Thank you for the opportunity to respond to the exhibition of the Richmond Valley Solar Farm (project SSD-41020244) application documents. Henribark Pty Ltd is the immediate northern neighbour to the project (Lots 50 and 51, DP755706) and fully supports the development proceeding, mindful of the matters that we have included later in this response. We support the development of renewable energy projects recognising that there are imperatives both in terms of environmental harm reduction and establishment of sufficient generating capacity to address the reductions as fossil-fuelled plants reach (or exceed) their operational lifespans. We also note that we have not been identified in the mapping as a 'private receptor', only as we have no permanent residence on the property, which we believe the department should allow consideration for.

Detailed response to the EIS

Specific comments on the BDAR (Appendix 14)

**FIGURE 6.12**

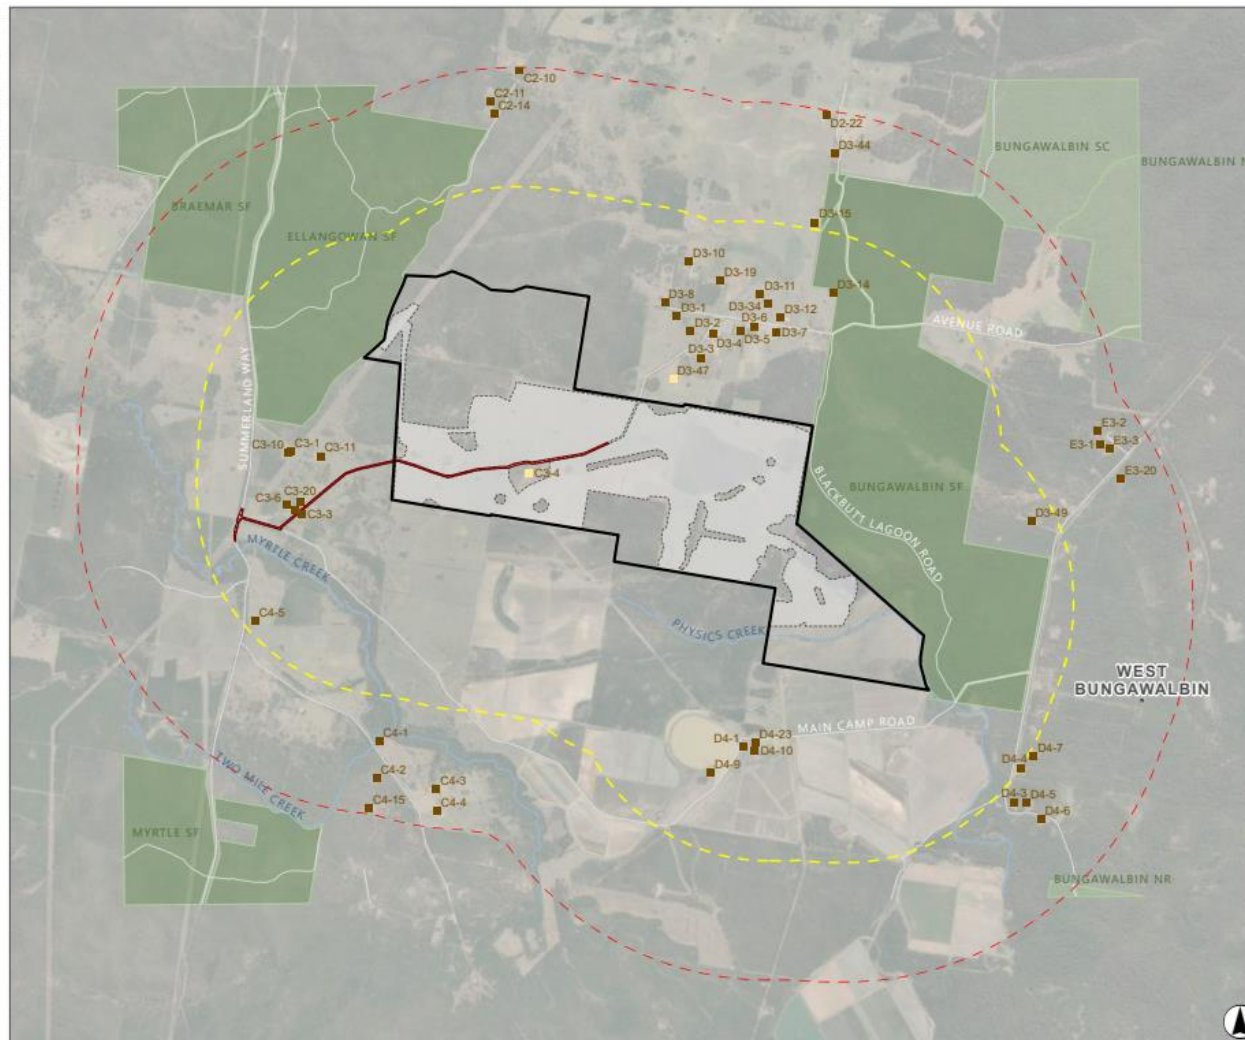
In regard to the viewpoints, again, our property has not been identified in EIS Figure 6.12 as being a private receptor even though the land has moderate to high visibility of the solar arrays along the southern boundary and from our north-western parts (EIS Figure 6.14).
